**Consultation Response from KC,
Trees****2021/91506 Shop Lane, Kirkheaton, Huddersfield, HD5 0DB****Reserved matters application pursuant to outline permission 2014/92535 for erection of 48 dwellings, formation of access and associated infrastructure****Date Responded:09/06/21****Responding Officer:JR****Responding Ref:85/91**

**SHOP LANE**

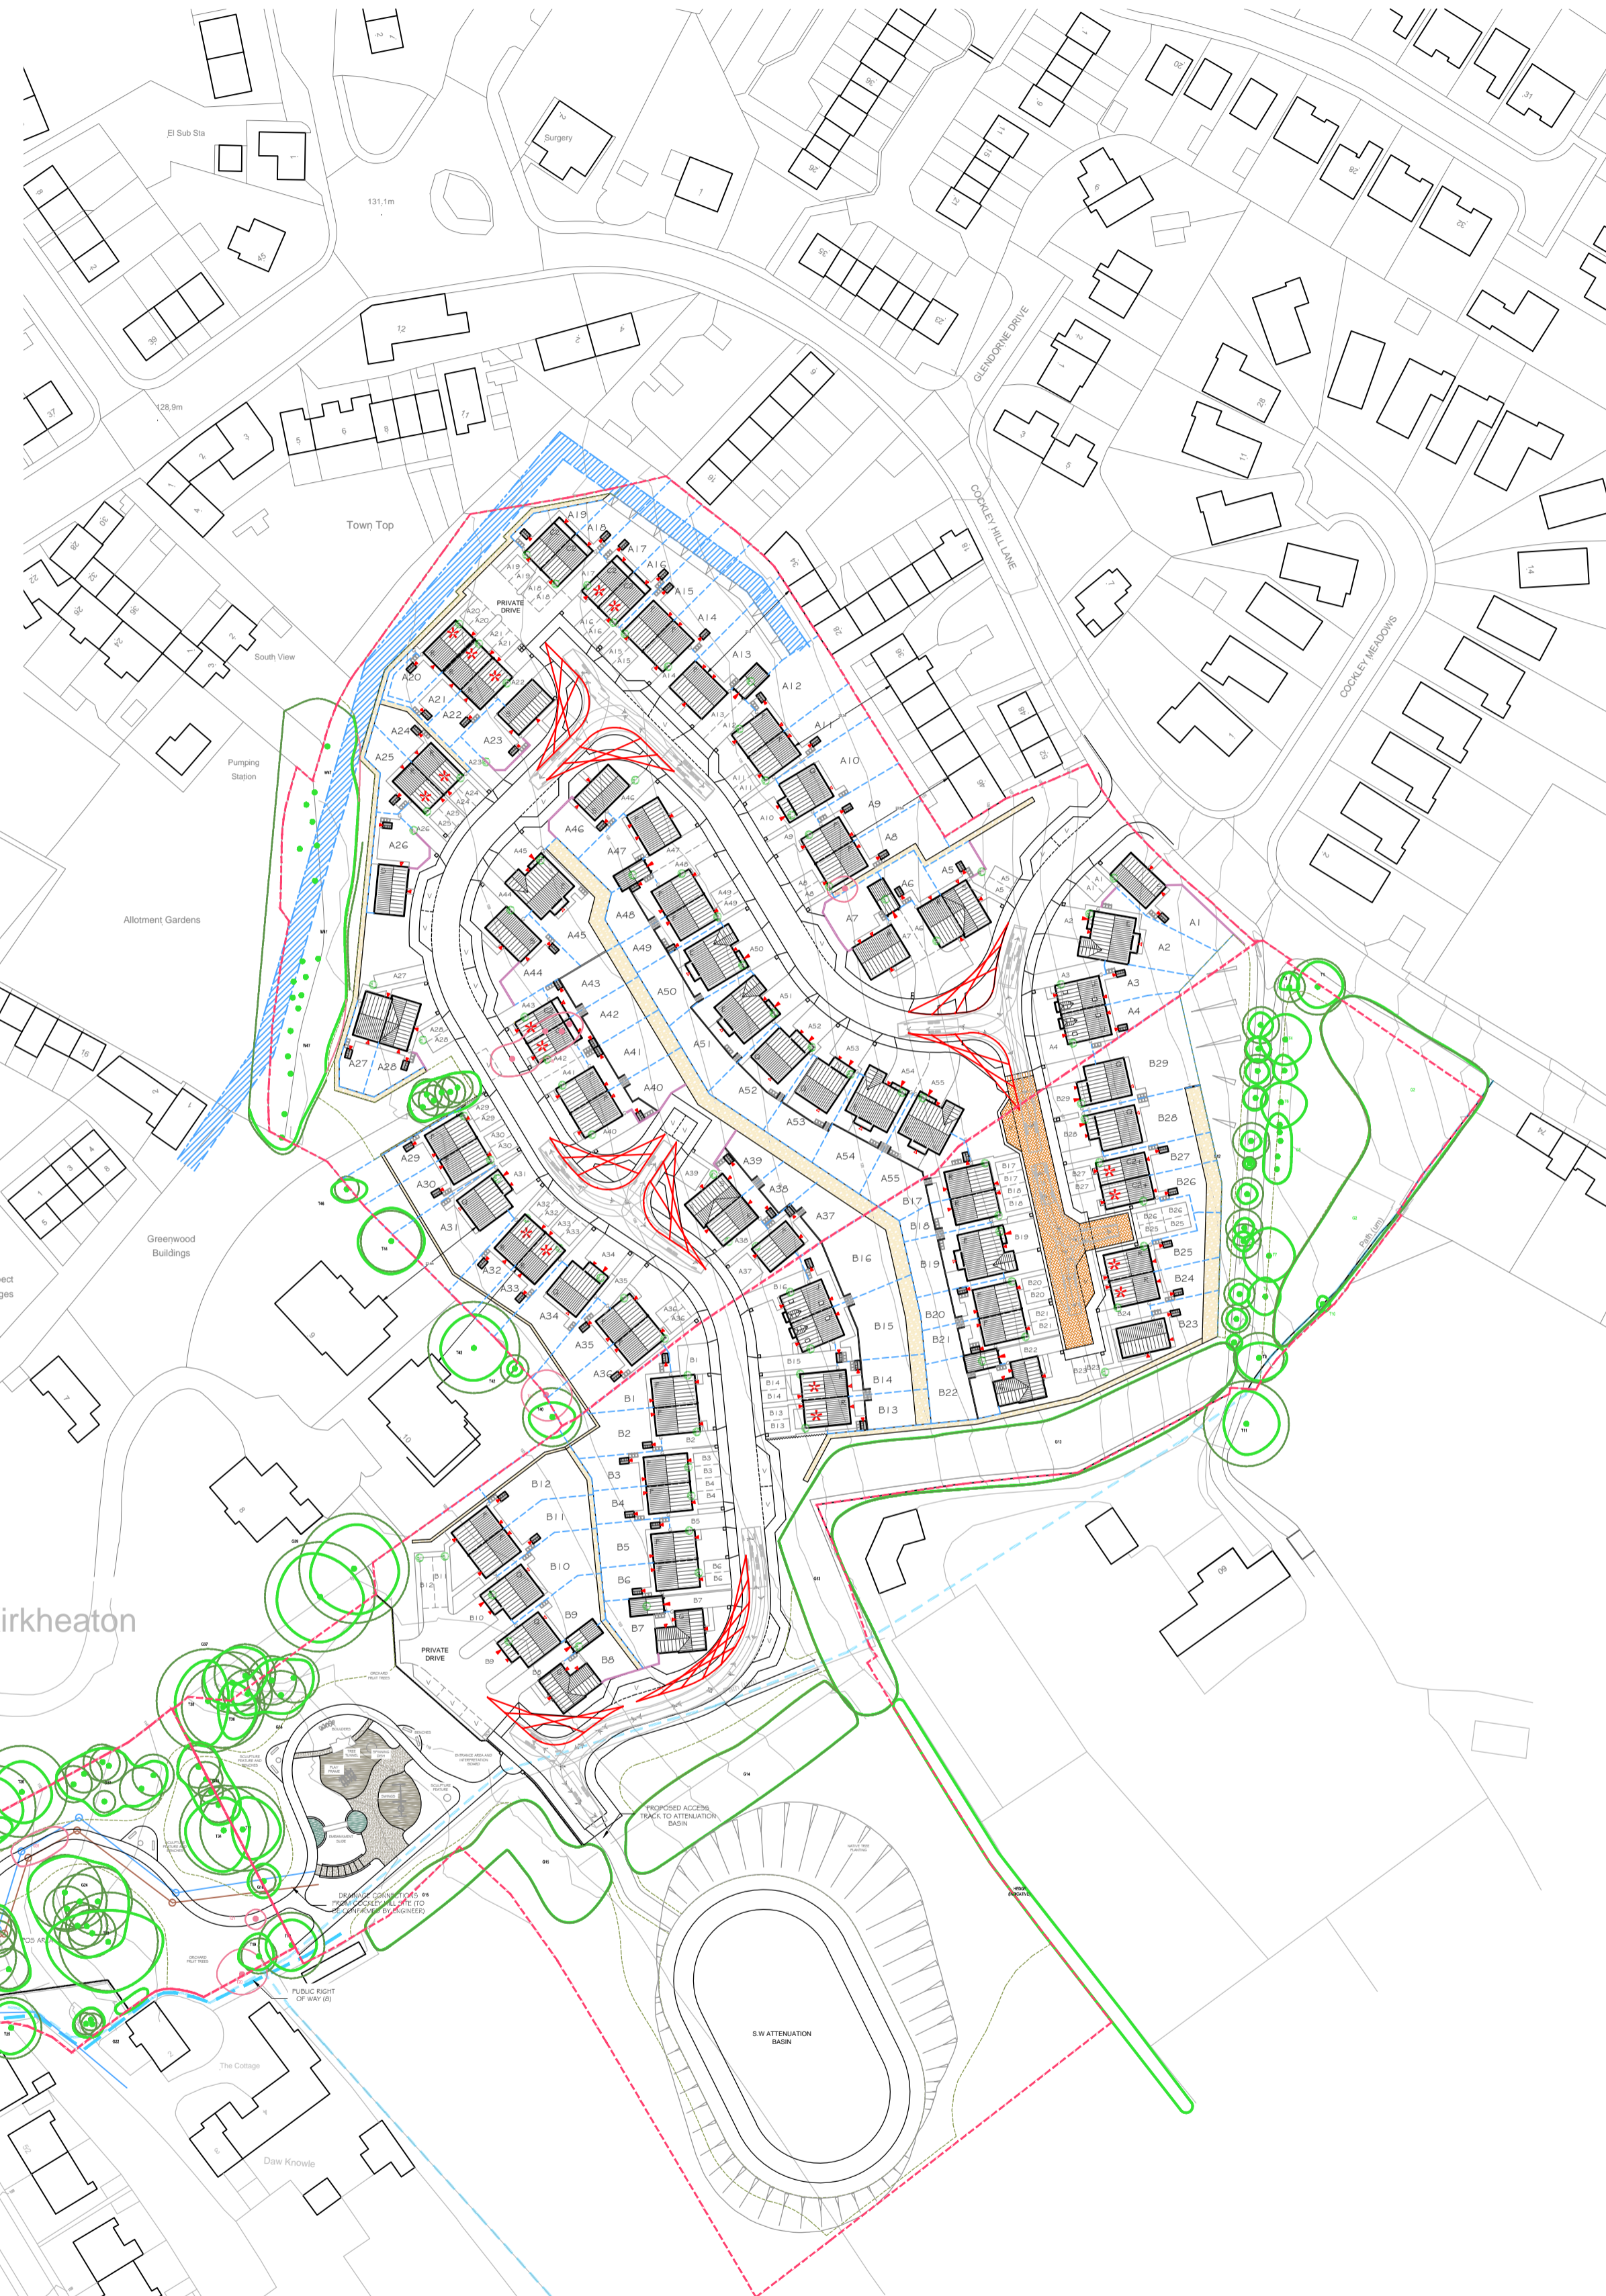
We also need to see more details about the proposed landscaping scheme to include but not limited to, species, size of planting material, tree pit types to be used, after care maintenance etc. Again, this should be predetermination.
